**From:**  
**Sent:** 13 November 2023 18:04  
**To:** DCAdmin  
**Subject:** Planning Application 2023/92712 - Care Home and 12 Res Units near 36 Oxford Rd

Proposed Bin Store Plan
1 : 25

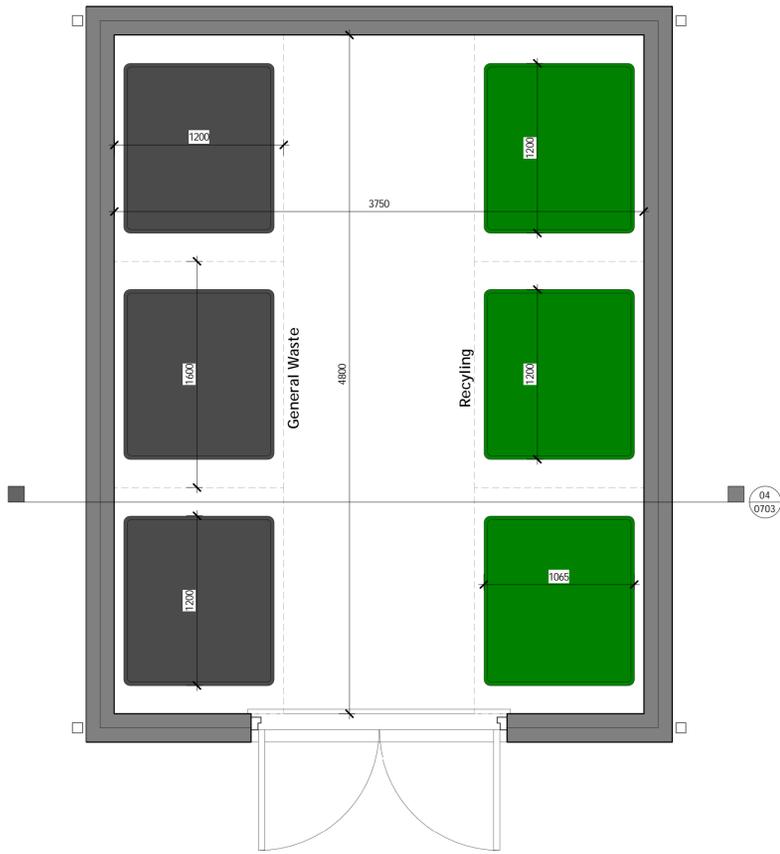
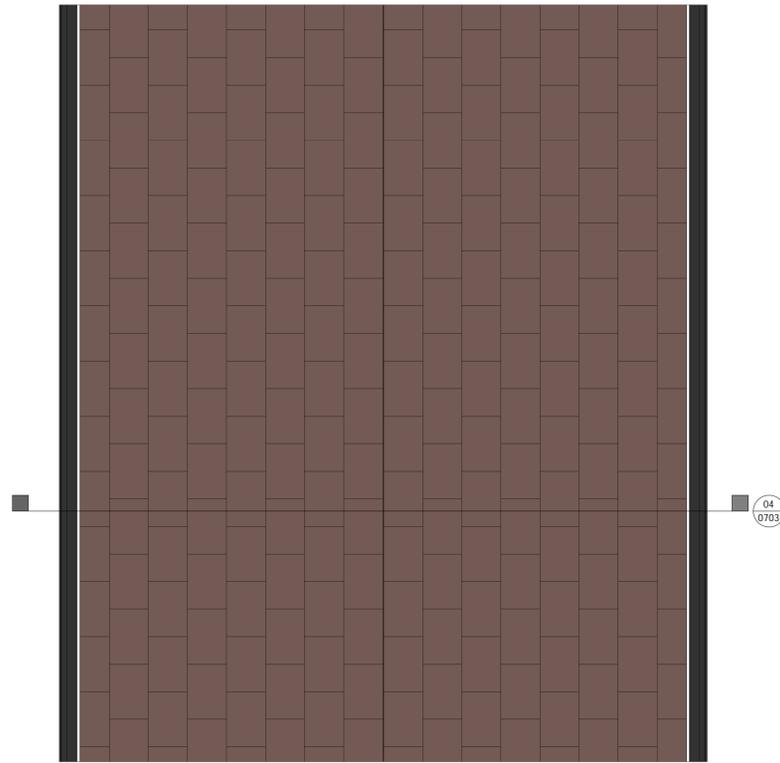
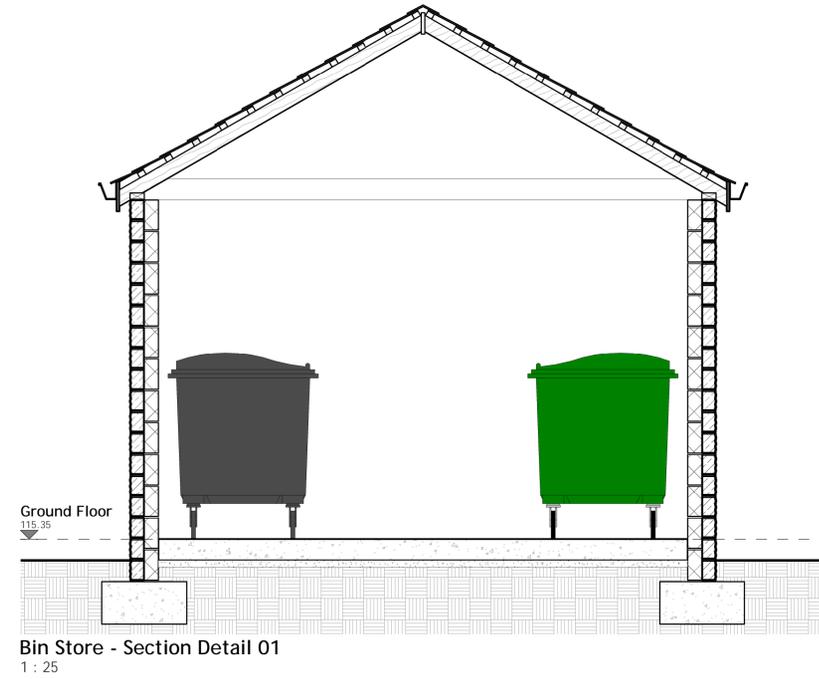
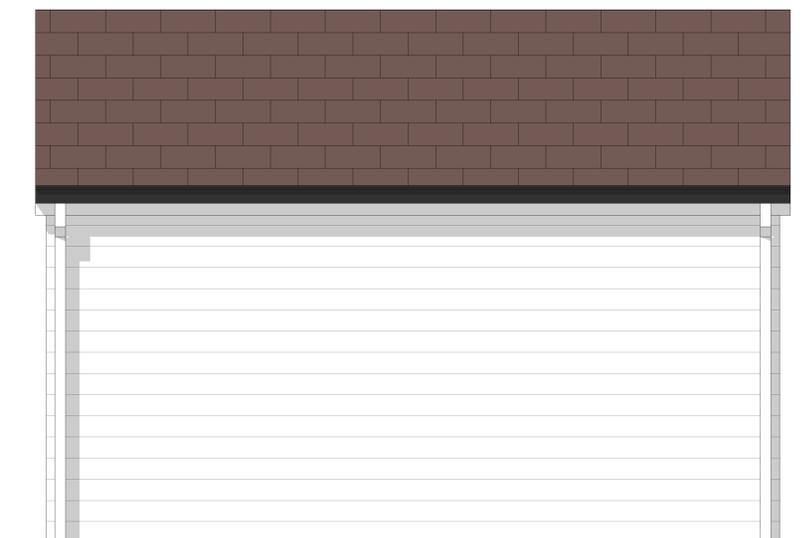
4. The bin storage area seems inadequate for the number of persons and the demands of a care home.
5. There is reference to Paladian green fencing in submitted documents but elevations do not show this. Where is it intended? If permitted it will create an "institutional" appearance- not one that suits a residential area.
